TfNSW Reference: SYD24-01344/05
DPHI Reference: SSD-63168959

**EXHIBITION OF EIS FOR NEXTDC S5 DATA CENTRE AND INNOVATION HUB - ADVICE ON AMENDMENT REPORT
269 LANE COVE ROAD, MACQUARIE PARK**

Thank you for providing Transport for NSW (**TfNSW**) an opportunity to comment on the amendment report for the State Significant Development Application (**SSDA**) SSD-63168959 for a data centre and innovation hub at 269 Lane Cove in Macquarie Park.

TITLE: SWEEP PATH ANALYSIS - ROAD 6
20 M ARTICULATED VEHICLE

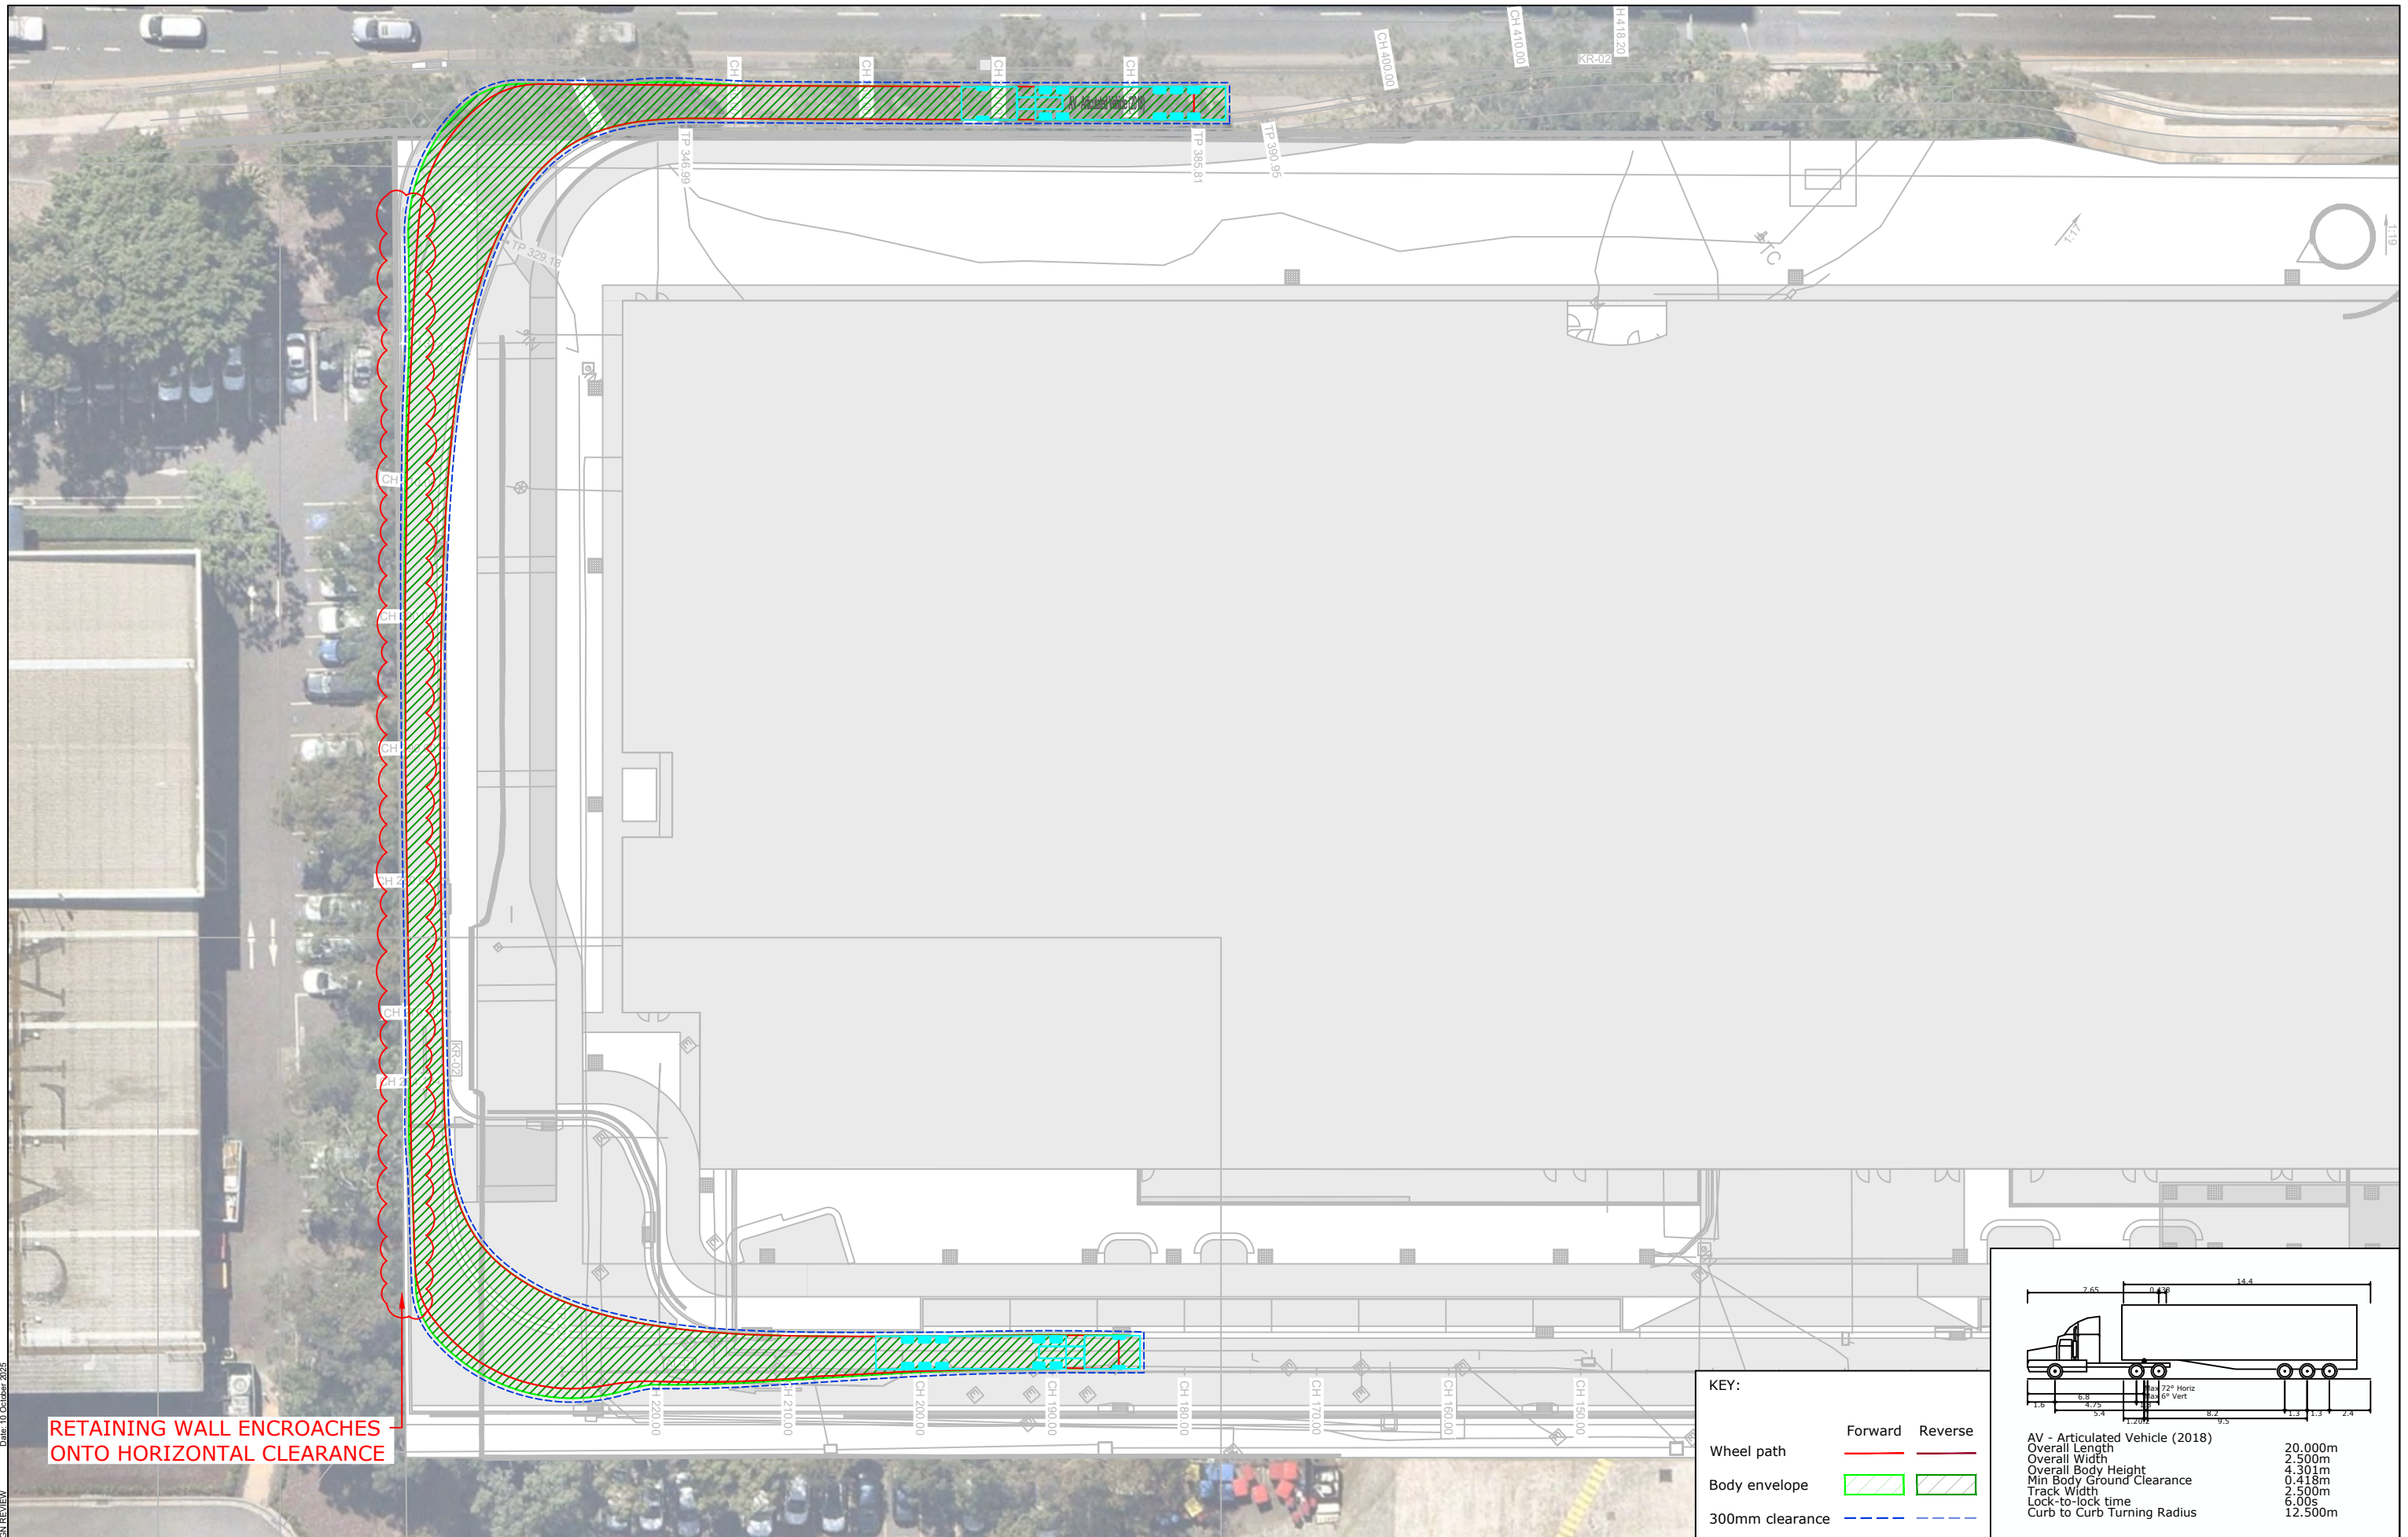
4. Road 6 half road construction	<u>Comment:</u> Large trucks turning into Road 6 require a minimum of 500mm clearance to obstructions on the outside of the vehicle. <u>Additional Information Required</u> Confirmation that no obstructions greater than 150mm above the road level are provided between the fence and the Road 6 kerb.
